**RE: Request for Further Information
Lingard Private Hospital Expansion (SSD-60316710)**

This letter is submitted to the Department of Department of Planning, Housing and Infrastructure in response to the Request for Further Information (RFI) issued on 10 December 2024, relating to SSD-60316710 for the proposed expansion of the Lingard Private Hospital.

5 DA. - PROPOSED SHADOW DIAGRAM - 21 JUNE 1300
Scale 1:400

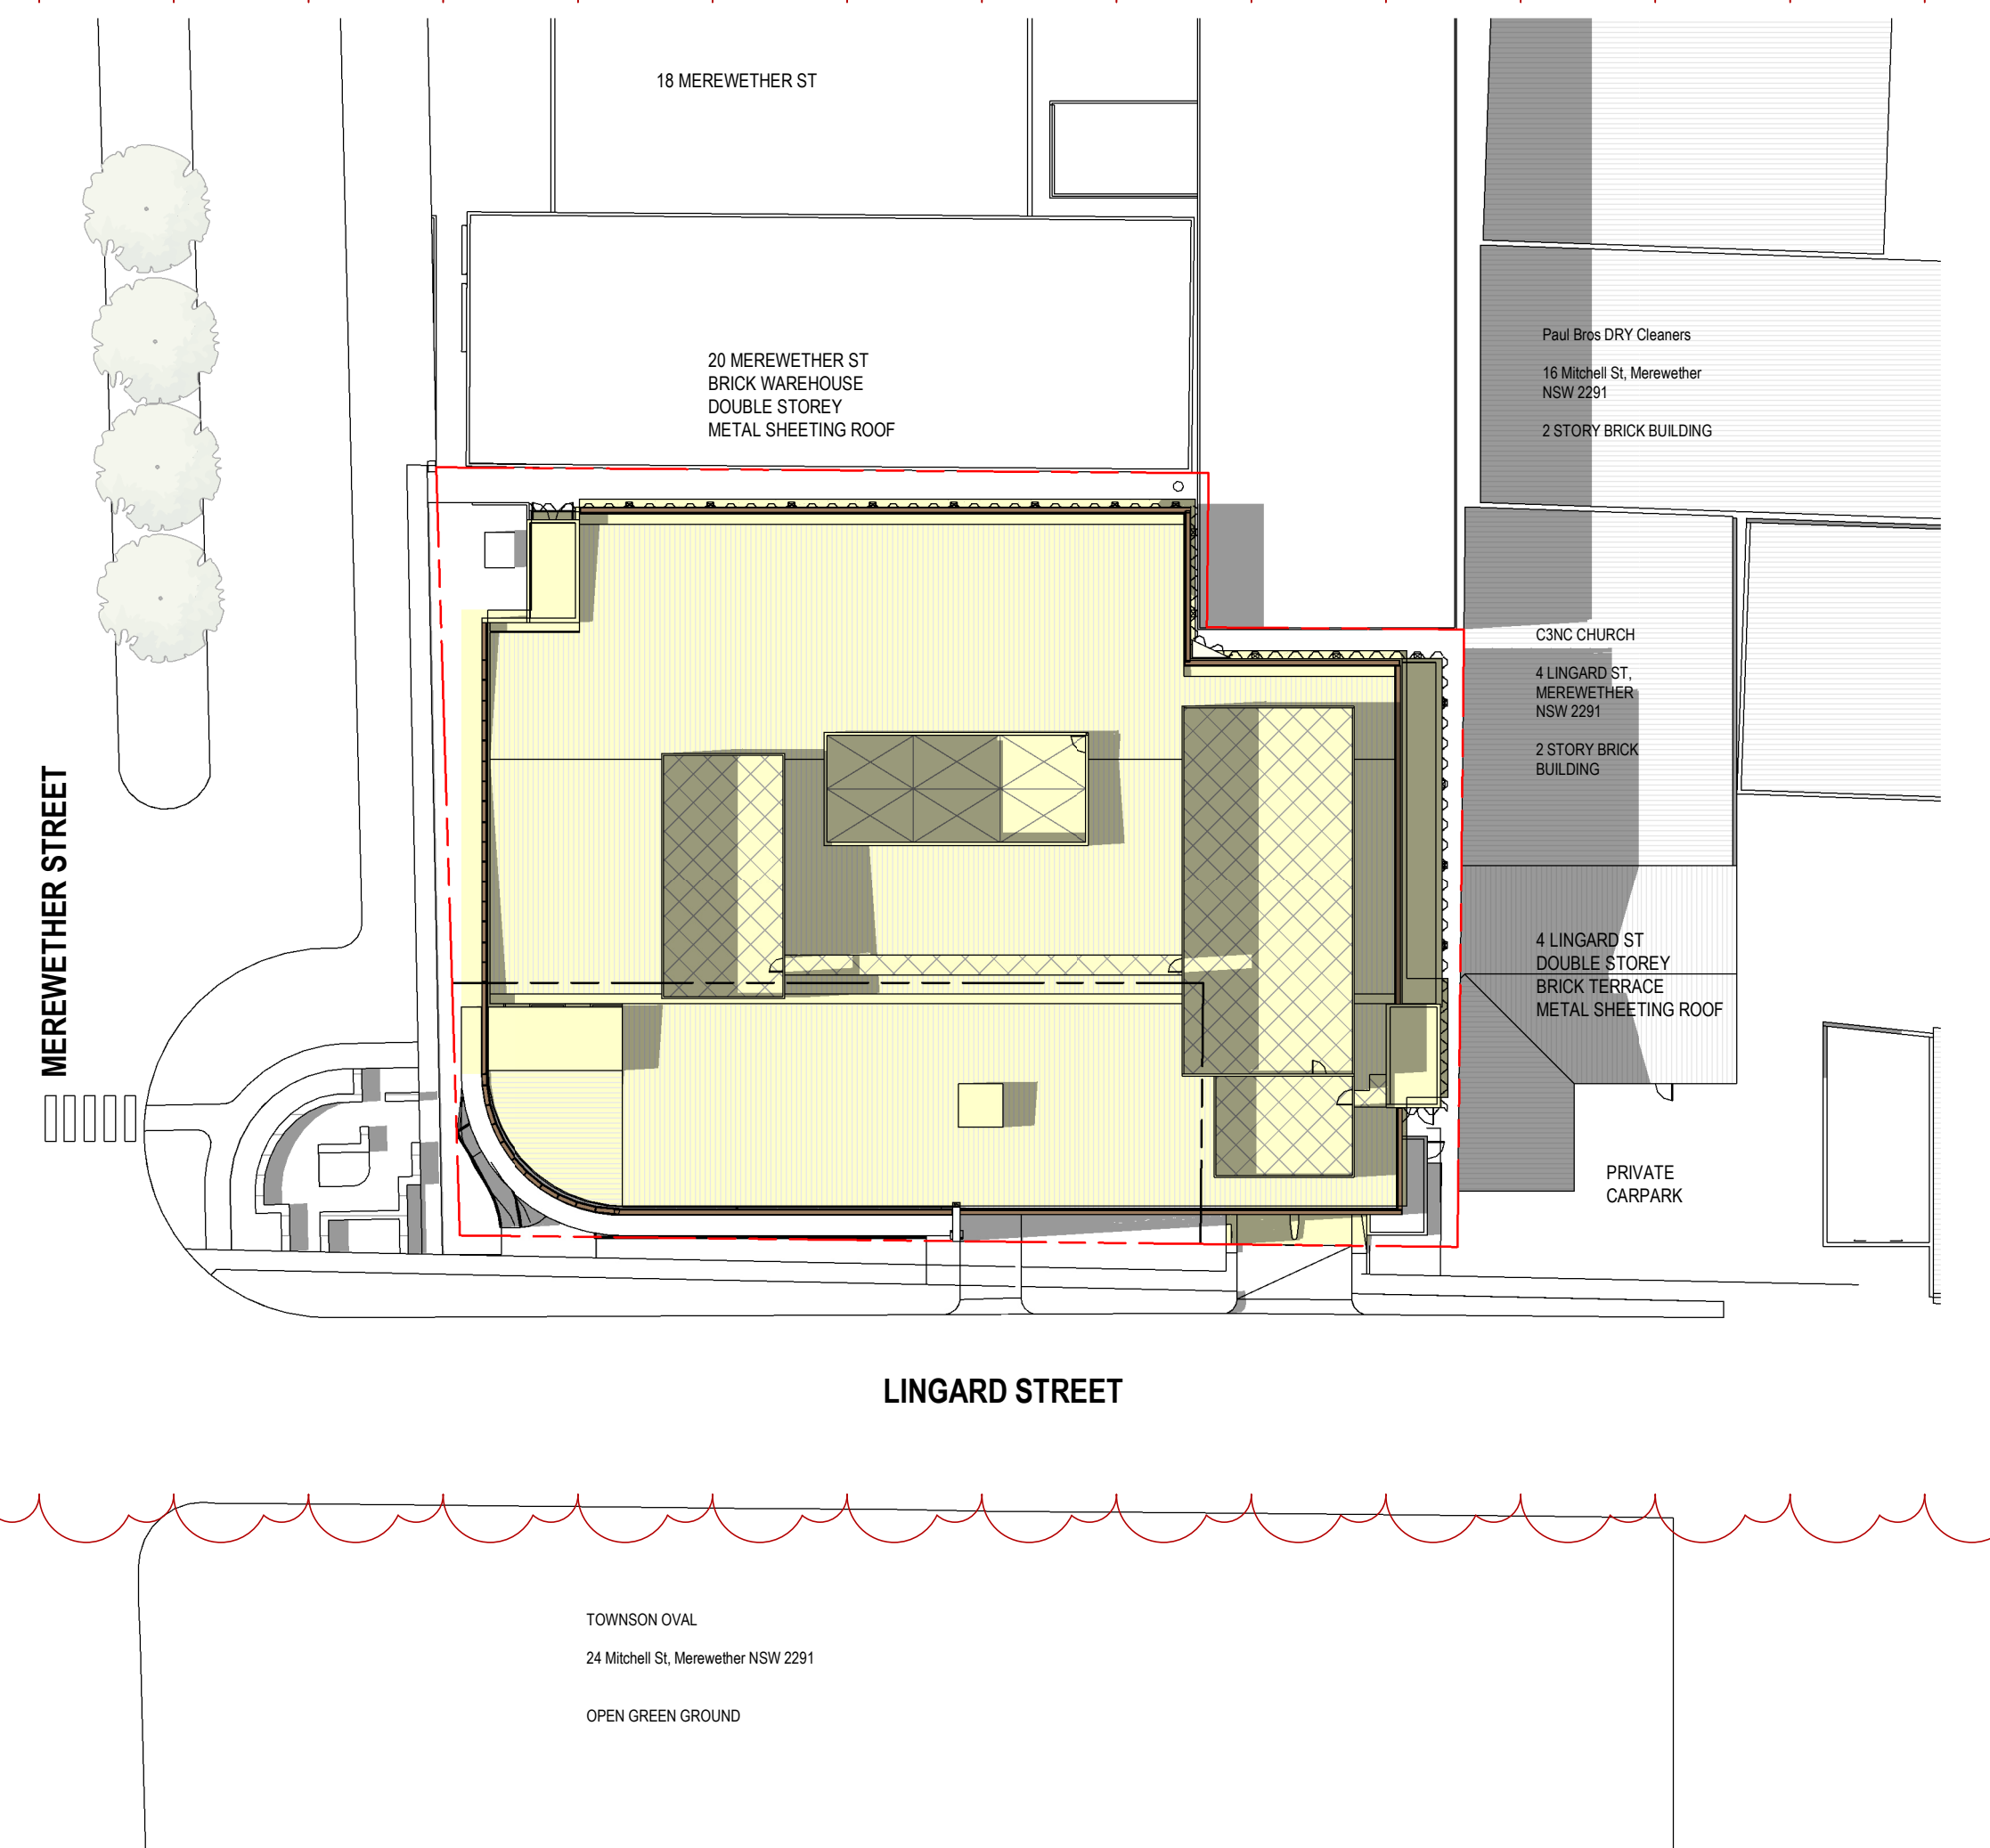
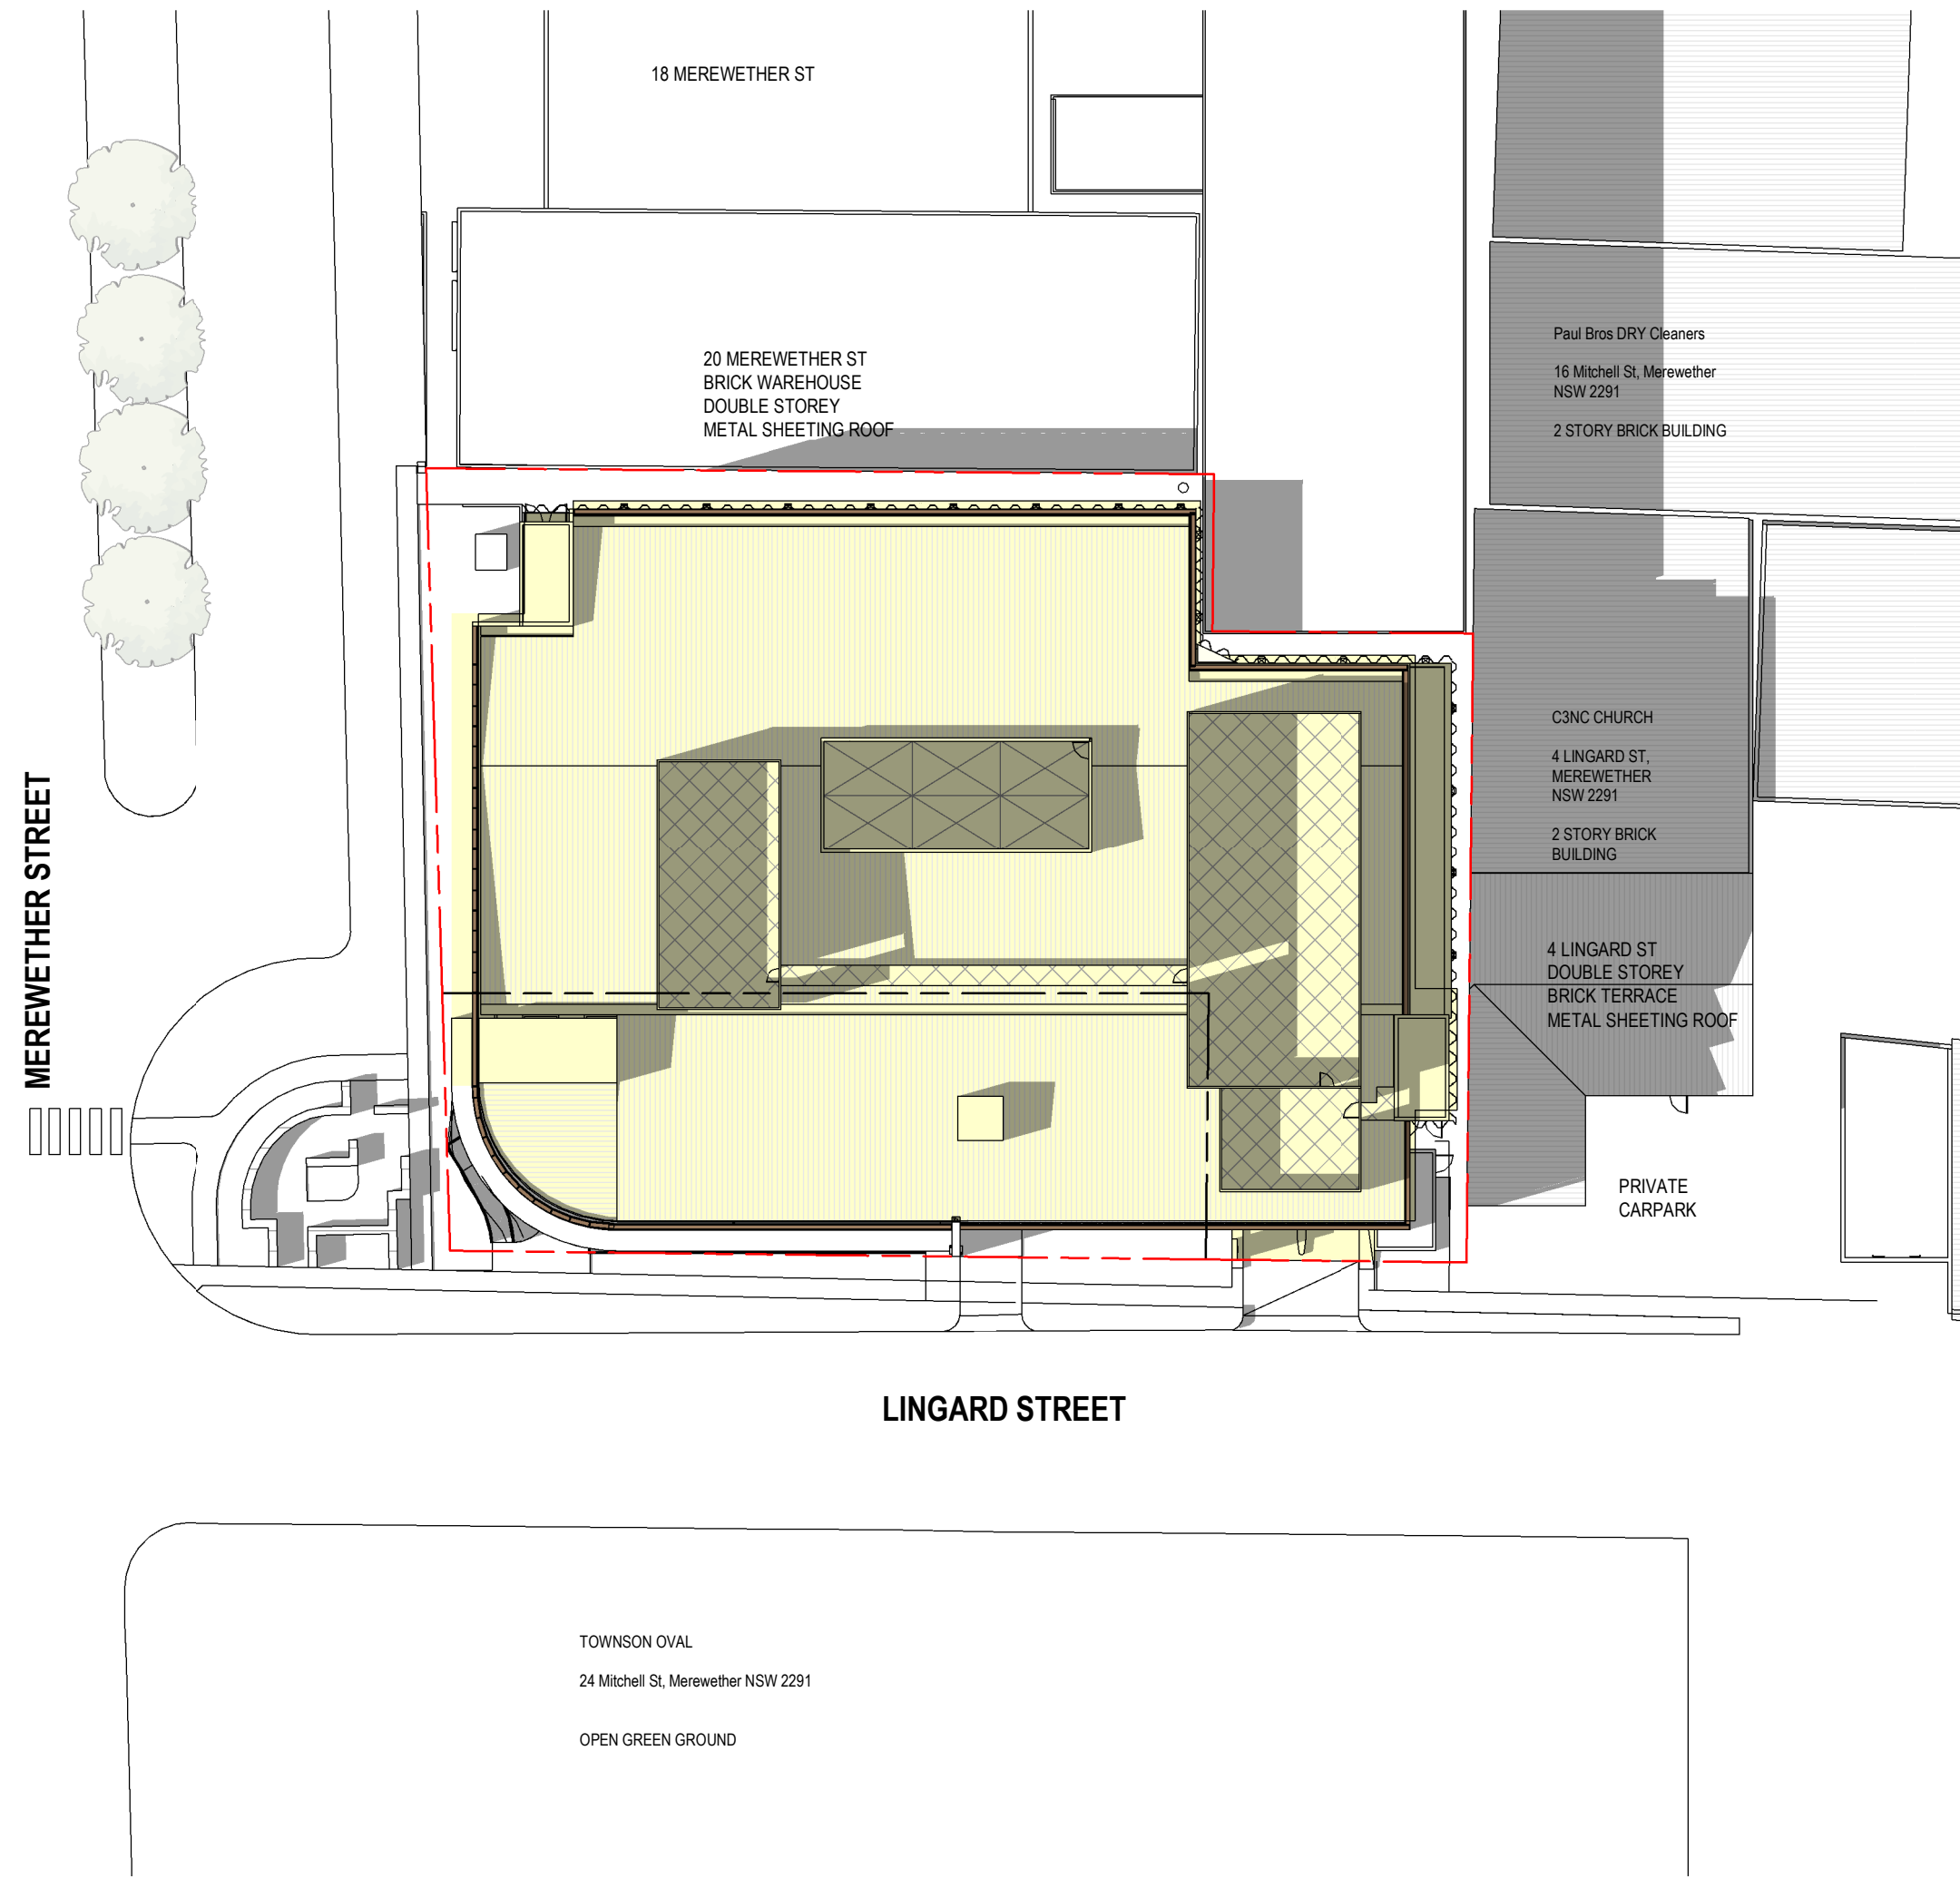
CN's concerns regarding residential amenity remain. The amended architectural plans do not include hourly shadow diagrams or 3D shadow analysis to identify the habitable rooms and private open space of residential properties, as previously requested. The shadow impact to Mitchell Park has not been adequately addressed.

The non-compliant height coupled with reduced setbacks on the eastern boundary of the Hopkins Precinct, exacerbate the amenity impacts. CN recommends the design is amended to reduce the bulk and ensure upper floor levels comply with the setback requirements and maximum building height development standard. CN recommends the applicant is required to submit additional shadow diagrams at hour intervals between 9am and 3pm during the June 21 winter solstice.

Additional shadow diagrams have been provided at Appendix A. The overshadowing of Mitchell Park is minimal, occurring only at 9 AM during winter. The affected area consists of large trees and on-street parking that would naturally be in shadow. The proposal ensures ample daylight reaches the trees and surrounding area at all other times.

The amended shadow diagrams include percentage calculations for the surrounding residential dwellings and confirm compliance. The most significant impact is on 11 Merewether Street in the afternoon; however, the existing shadow diagrams show that this is also the present state, refer to Figure 1 & 2 below. In the previous iteration of plans the second level wall was also setback further from this boundary.

Overall, the proposed height variation does not result in any unreasonable adverse impacts on neighbouring properties in terms of bulk, scale, overshadowing, or privacy. The minor exceedance is justified by the functional necessity of the affected building elements and their limited contribution to the overall form, ensuring a well-balanced outcome that meets the intent of the planning controls while supporting high-quality urban design. Additional shadow diagrams are provided at Appendix A.
